**Consultation Response from KC,
Highways Development Management**

2024/90769 adj, 27, Riley Park, Kirkburton, Huddersfield, HD8 0SA

Erection of one detached dwelling and associated works

Date Responded: 13-8-2024.

Drawn	Checked	Date	Scale	Revision
DB	AH	18/08/2023	As @ A1 indicated	
Client	Rayner Developments			
Project	Belfry			
Title	Site Sections			
Dwg No.	3106-003

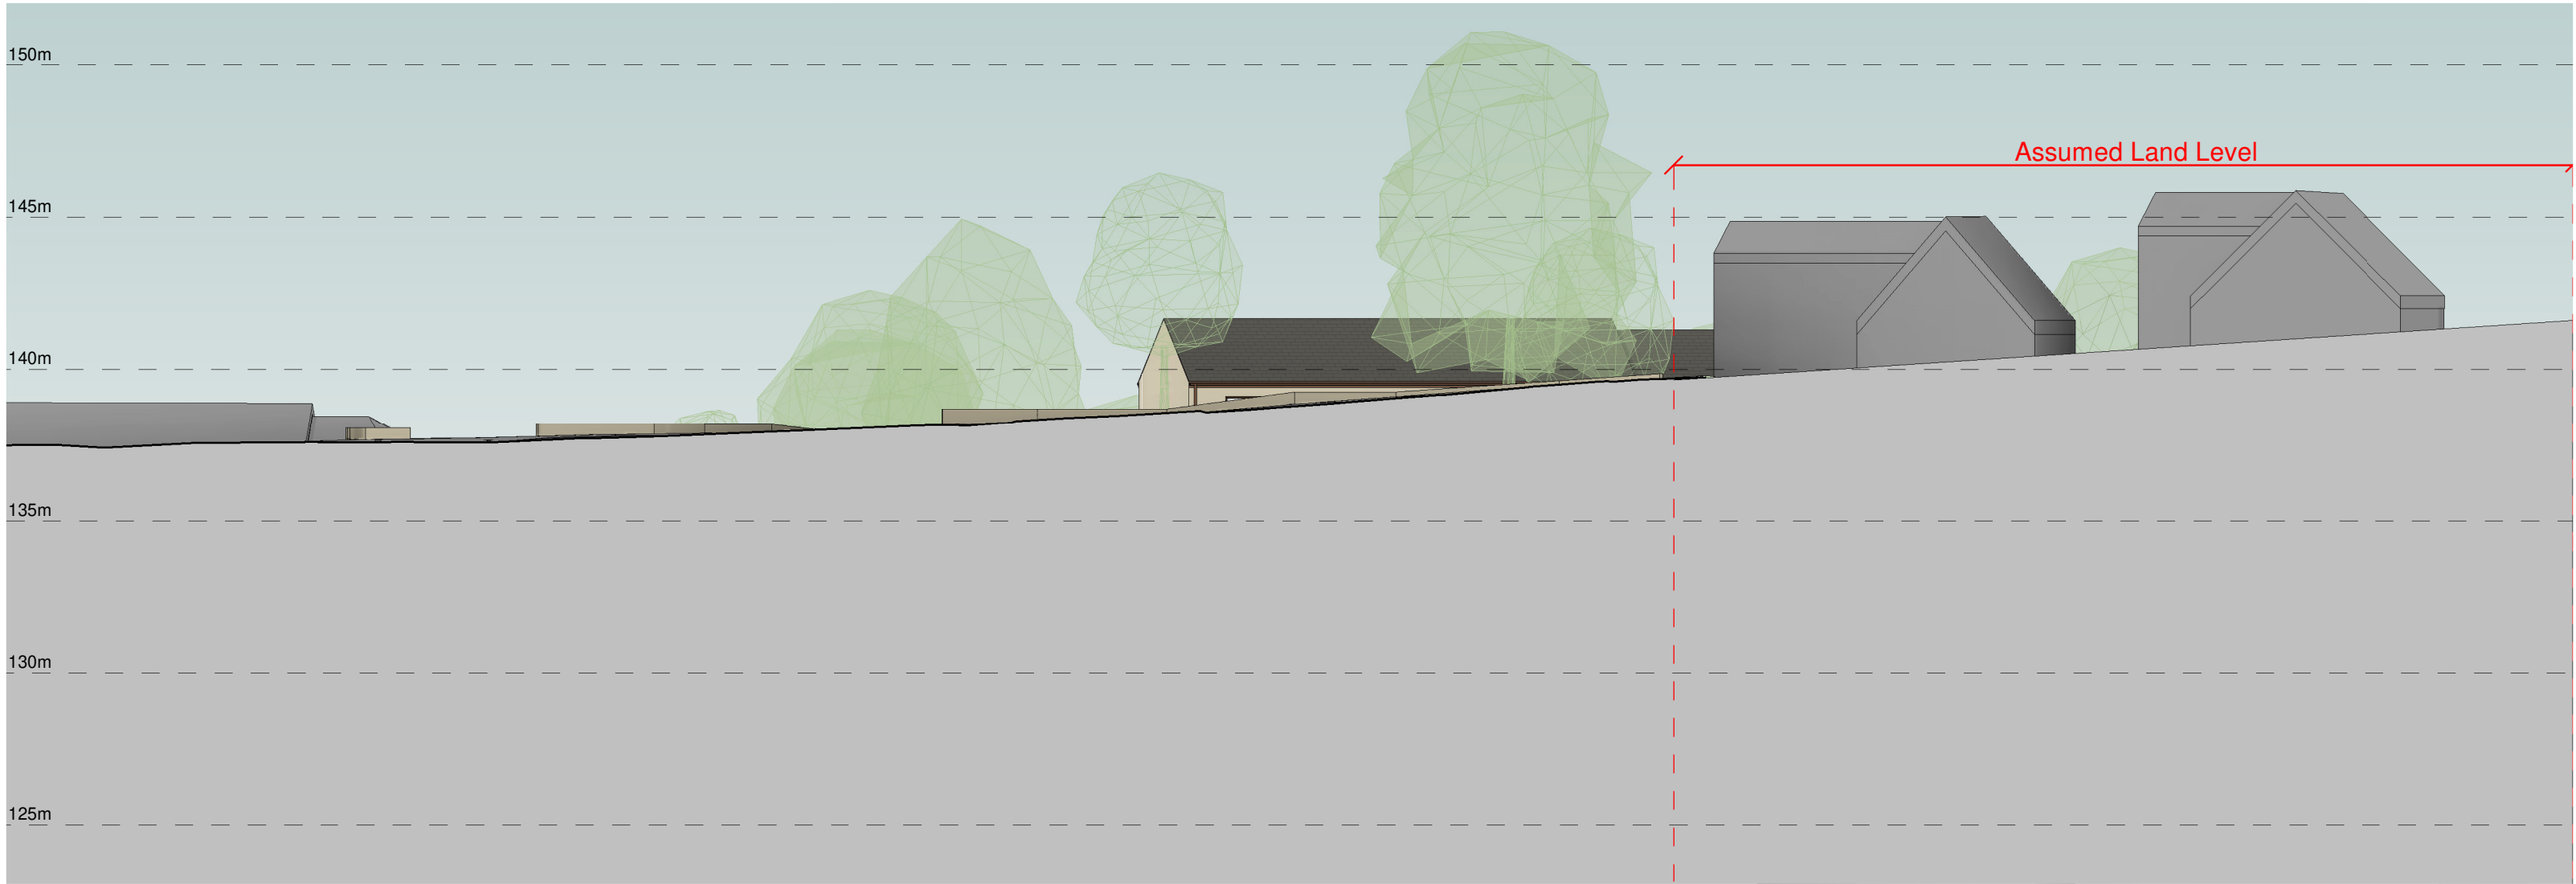
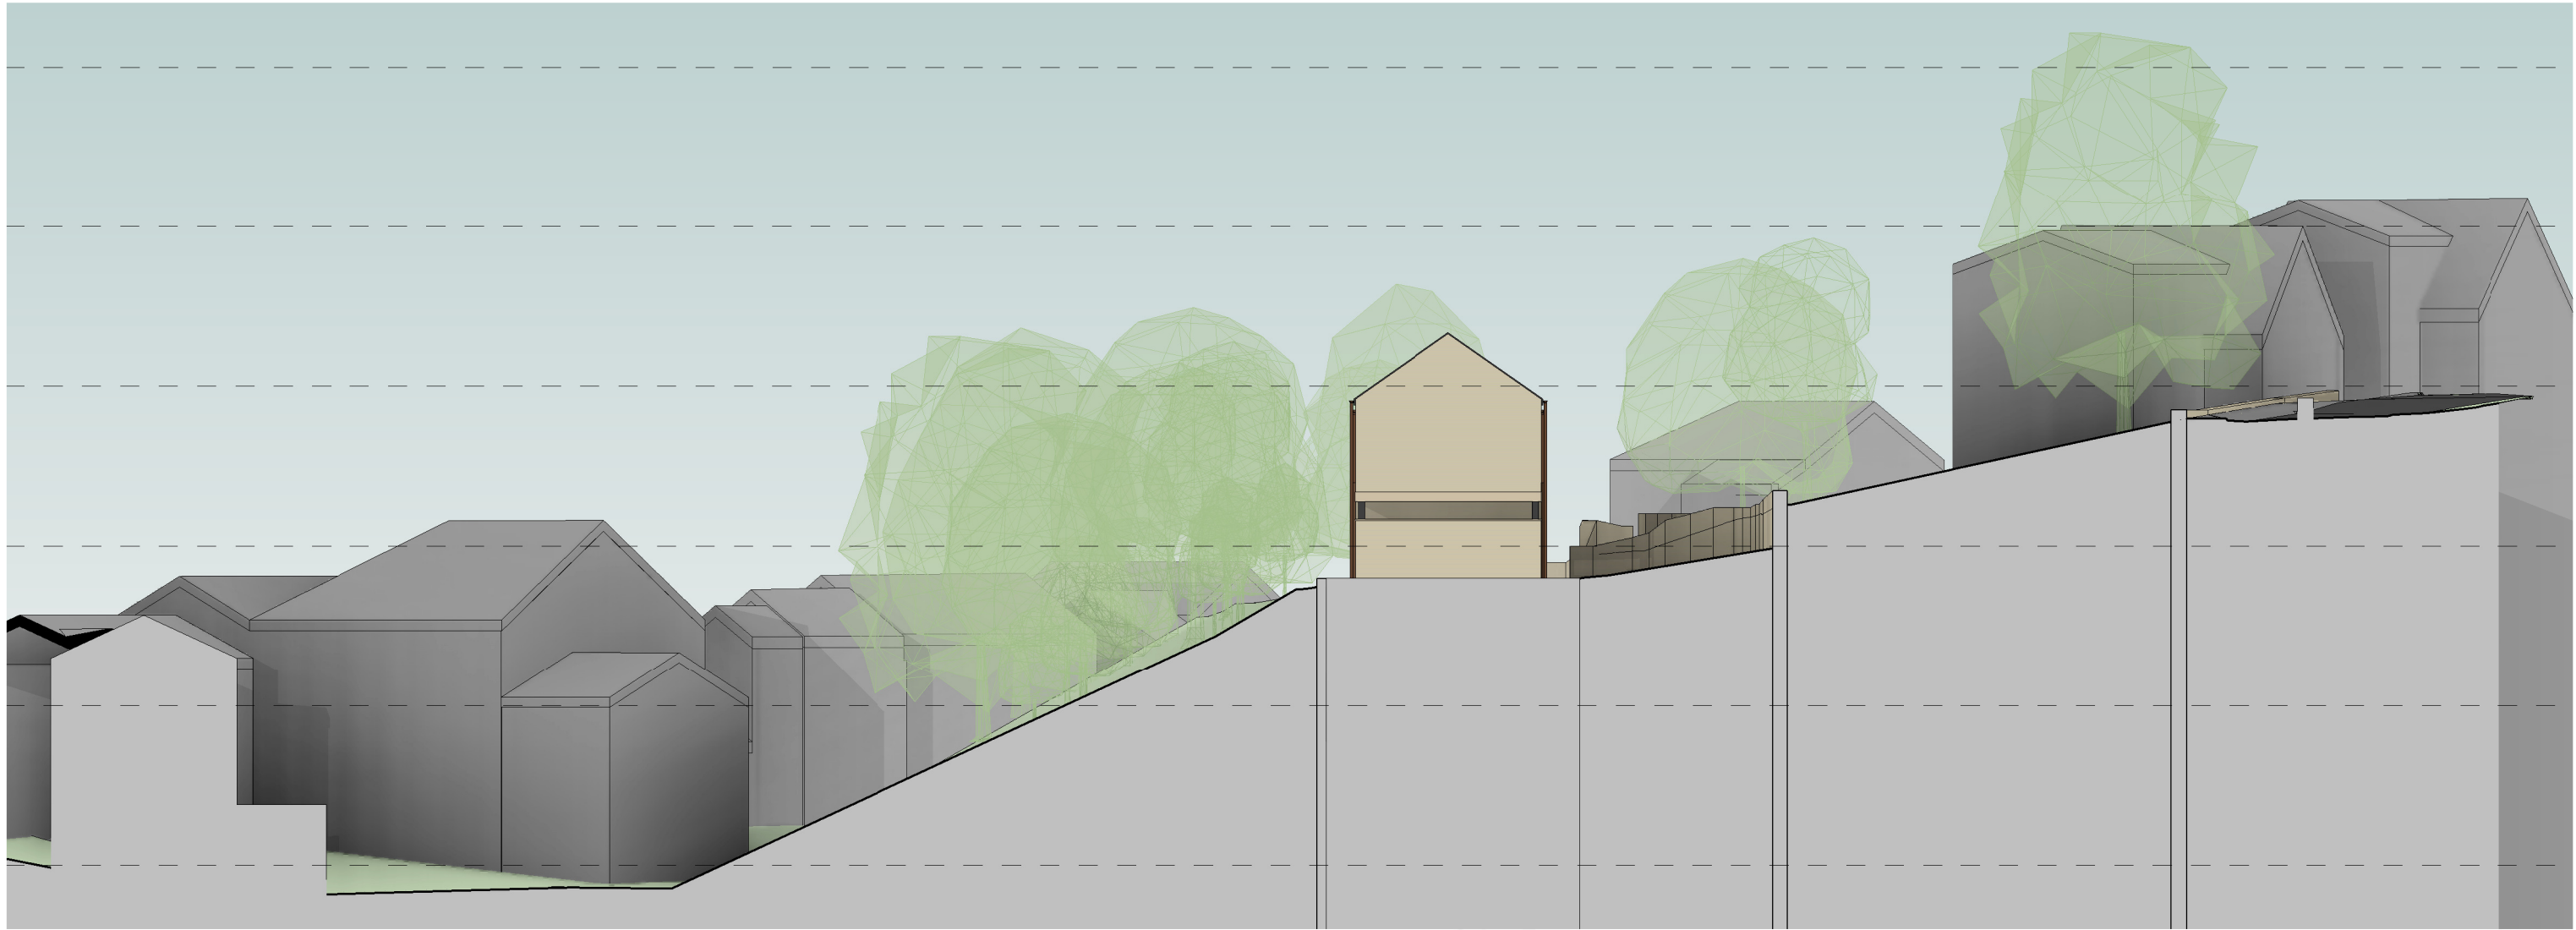
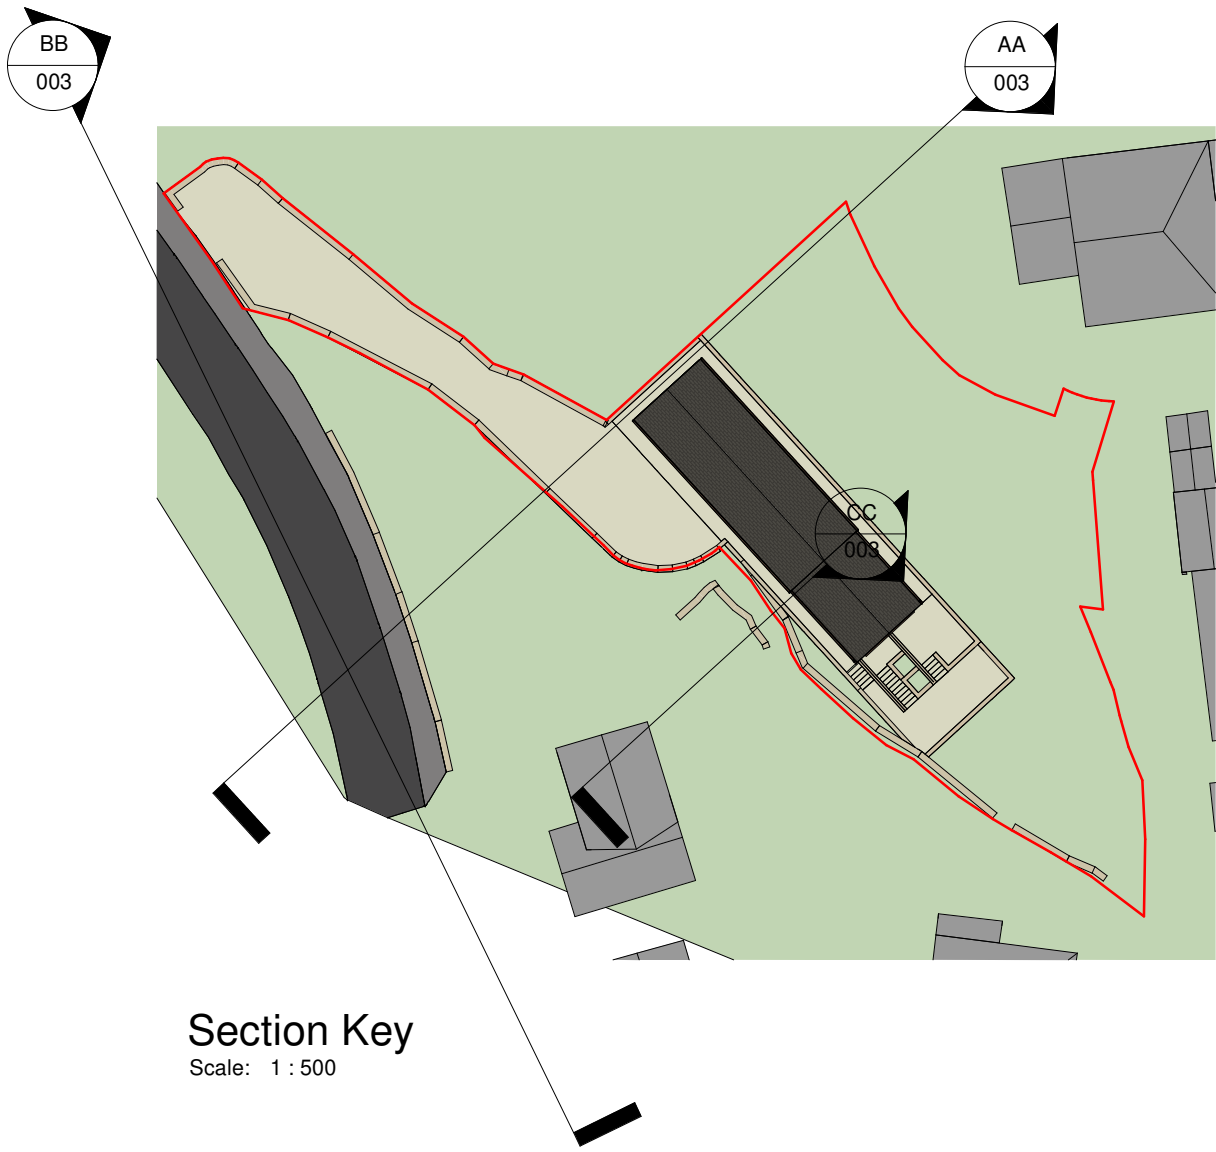
The Highways Structures Section asked that the applicants should submit fully detailed and dimensioned X-sectional drawings perpendicular to Riley Park in the vicinity of the proposed access road to assess the impact of their proposals on the adjoining highway to determine whether a formal technical approval (via submission of an AIP) will be necessary.

These don't appear to have been provided and further information is therefore still required.

Drawn	Checked	Date	Scale	Revision
DB	AH	18/08/2023	1 : 100 @ A1	B
Client	Rayner Developments			
Project	Belfry			
Title	Proposed Site			
Dwg No.	3107 -001

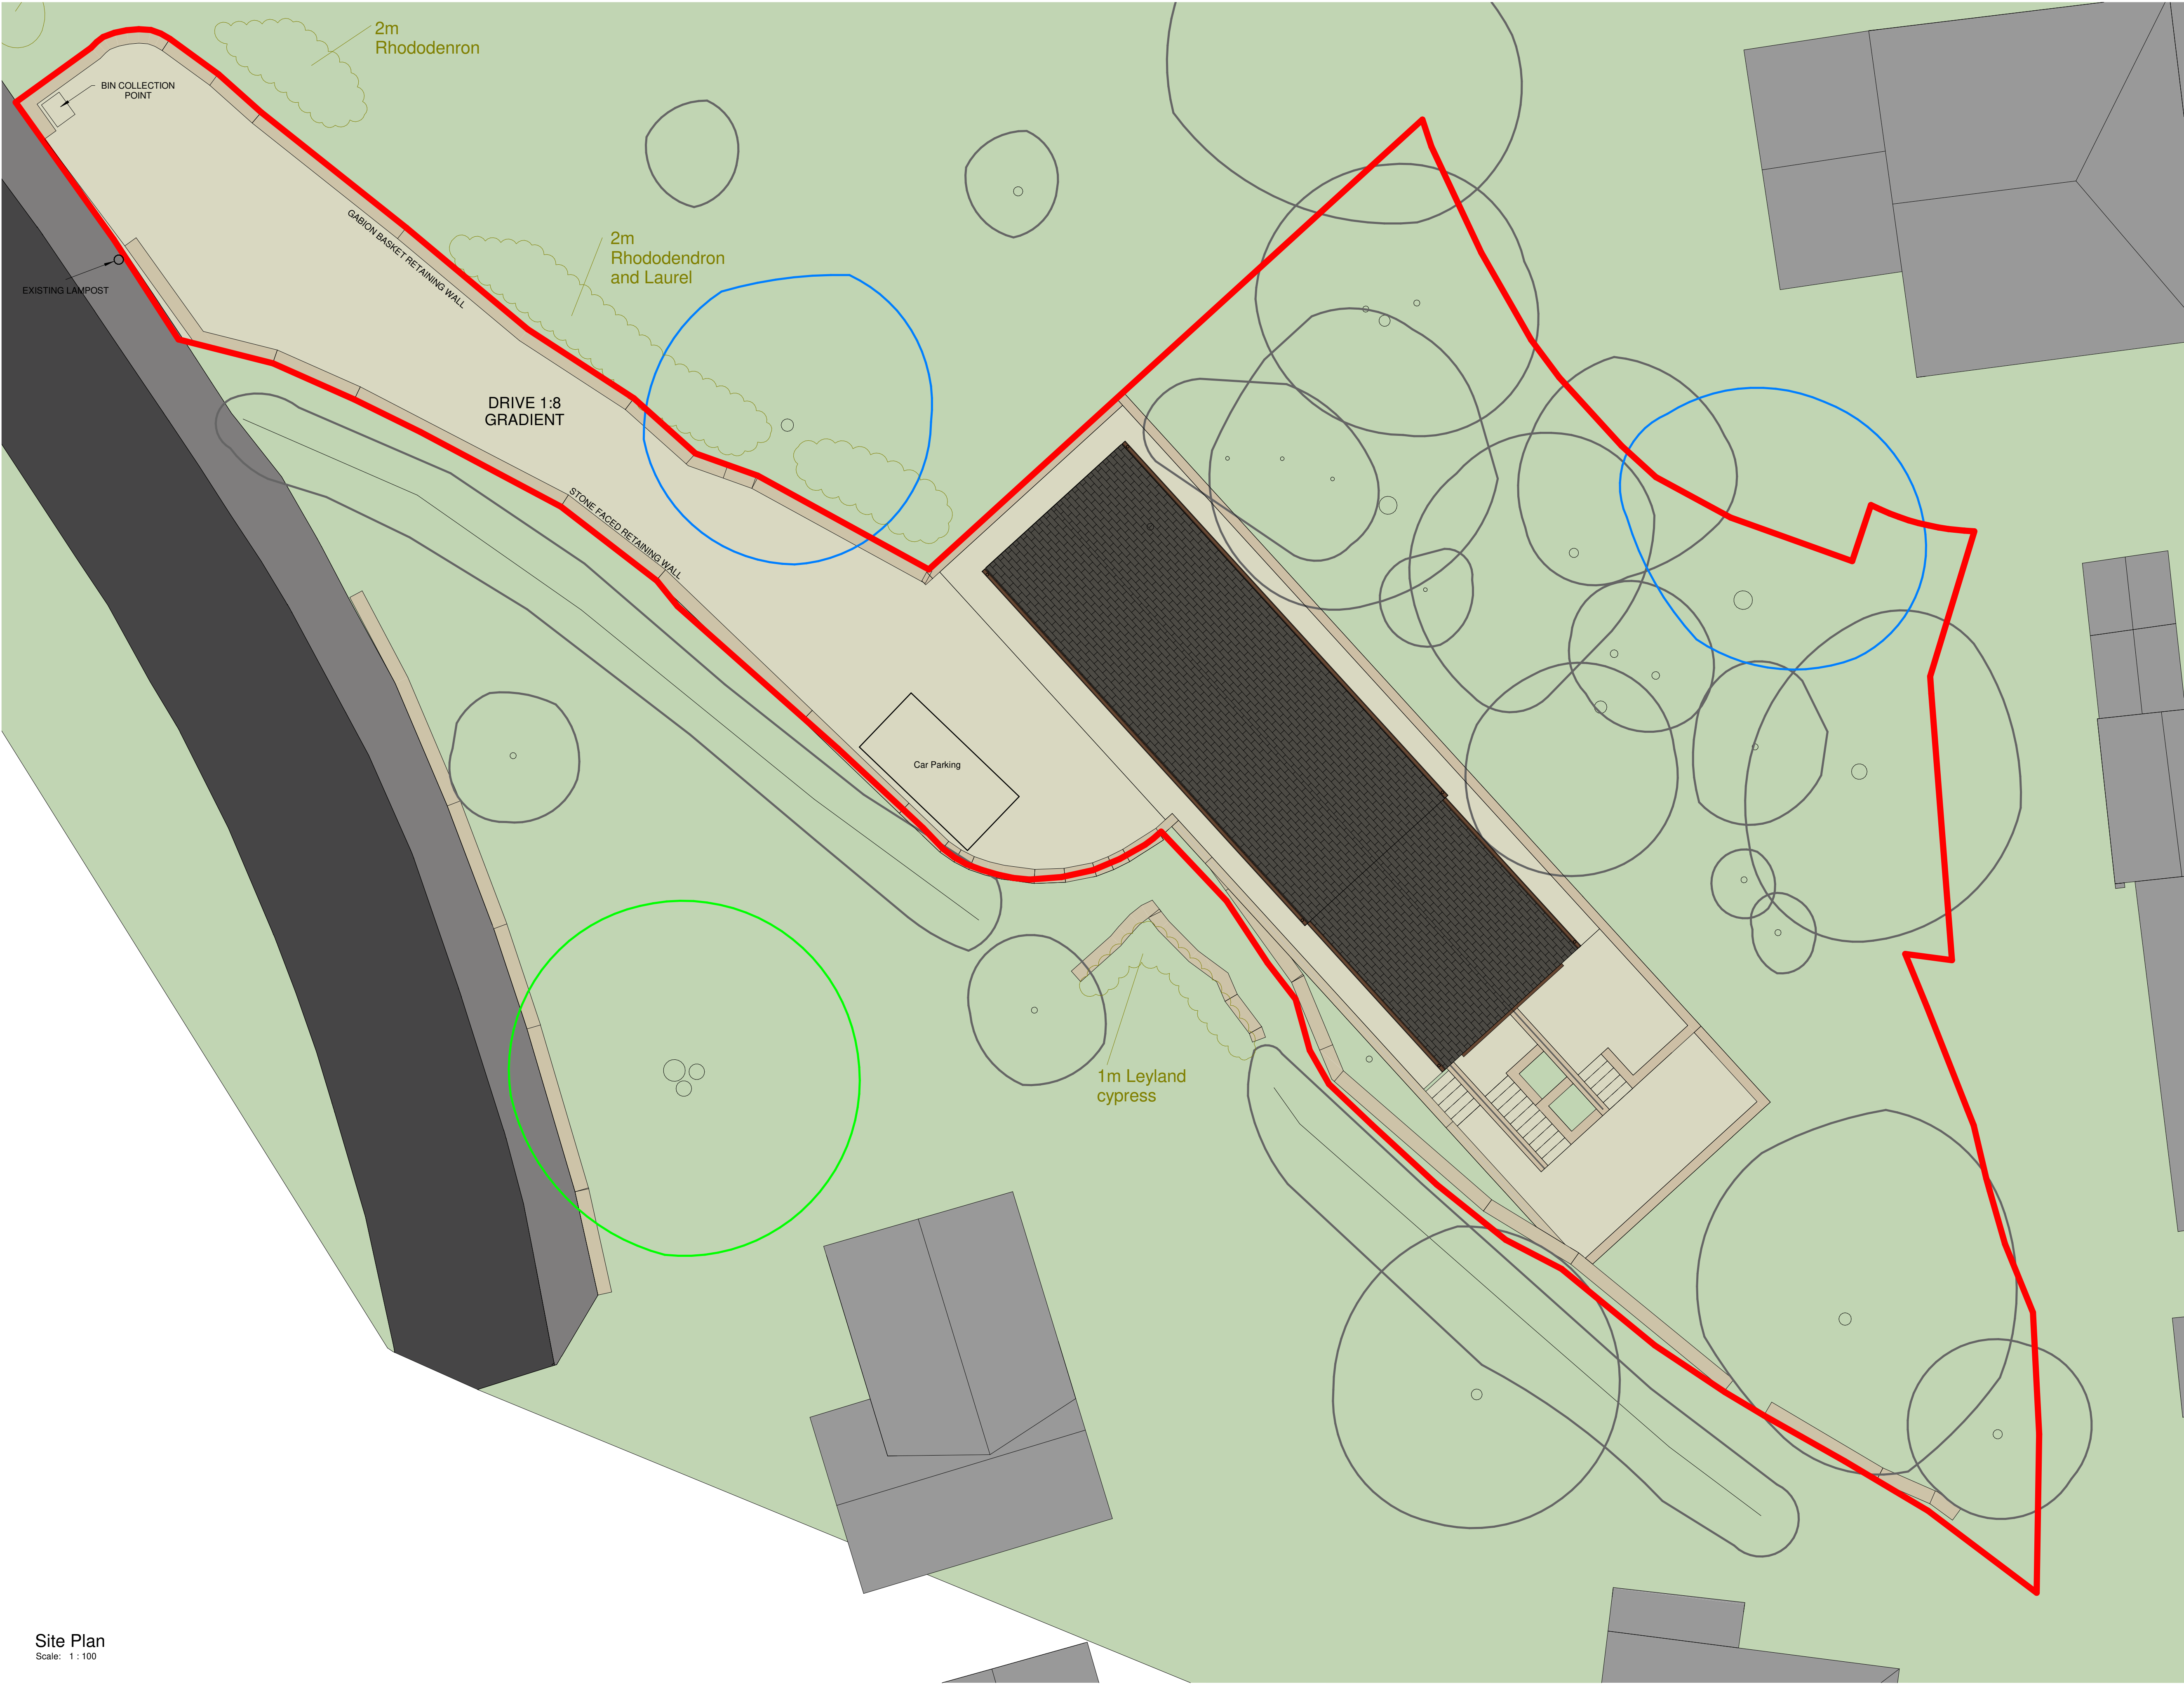
The highways consultation response dated 22nd July concluded that the bin collection point should be shown to be provided to enable bins to be presented on collection day without either obstructing the highway or proposed driveway.

The applicants have provided plan number 3107 001 rev B (Proposed Site) showing an acceptable bin collection point.
